From: Brian Holland
Sent: 16 June 2011 13:07
To: Planning.Responses
Subject: RE: Planning Consultation on: LU/156/11/DOC at Land South of Hearnfield Road

Engineer's Response:

Registered: 27-MAY-11
Site Land South of Hearnfield Road Littlehampton
Address:

Description of Works: Application for approval of details reserved by conditions 4, 5, 6, 9, 11, 13, and 16 following a grant of planning permission LU/63/10

SECTION - PRIVATE DOMESTIC SOAKAWAY

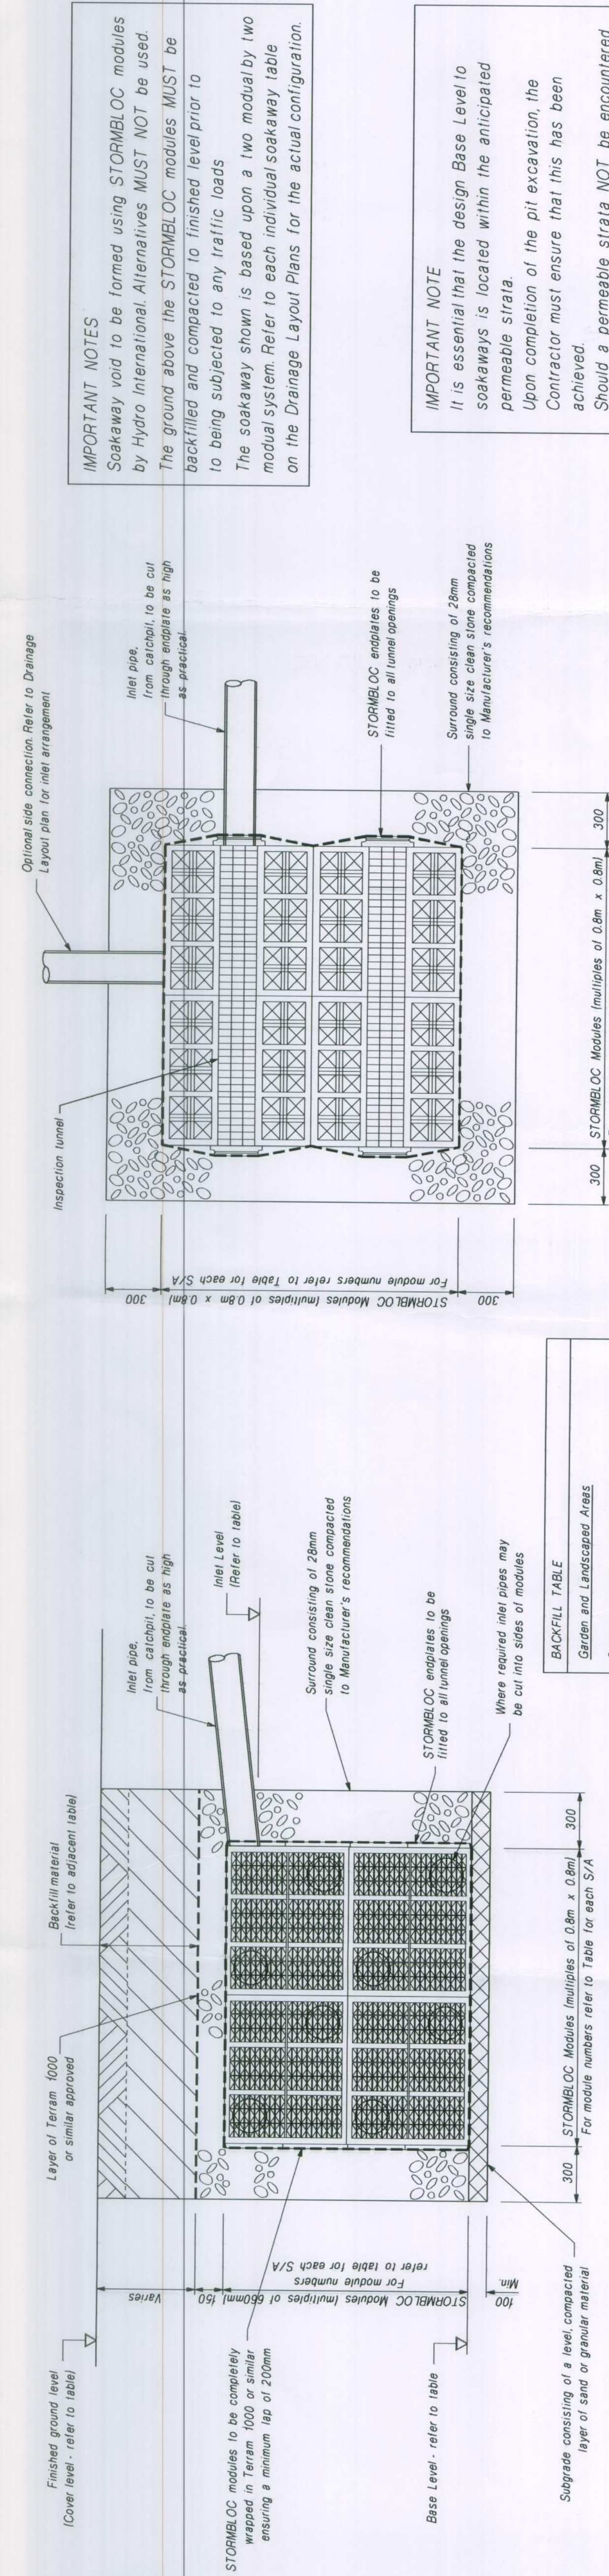
There are no design details supplied showing the ability of the proposed soakaways to work satisfactorily.

The Flood Risk Assessment submitted with application LU/63/10, to which this application for Discharge of Conditions applies, stated that '...further full-scale percolation testing to BRE 365 will be required to enable a detailed design to be carried out...'. There is no indication that these percolation tests have been carried out. Details are required of the results of these tests, together with details of the design of the soakaways showing each has adequate capacity for a 1 in 10 year return event to be stored between the base of the soakaway and the invert of the lowest incoming pipe and a 1 in 100 year return period event plus 30% (allowance for climate change) to be stored below the ground level. The soakaway should be able to discharge from full to half volume within 24 hours.

Details of groundwater levels throughout the winter months are also required to enable soakaway designs to be carried out. It is however noted that details of the preliminary testing carried out, which are included in the Flood Risk Assessment, shows groundwater levels at 6.5/7.4m below ground level. It is accepted in this instance that these details of groundwater level will be adequate as long as the proposed construction depth of soakaways is not within 1m of this depth.

BRE365 states that percolation tests should be carried out at the location of the proposed soakaways therefore, as soakaways are proposed throughout the development, testing should be carried out at various points across the site.

It is therefore recommended that Condition 9 on LU/63/10 is not discharged until adequate design information on surface water disposal has been submitted and approved..
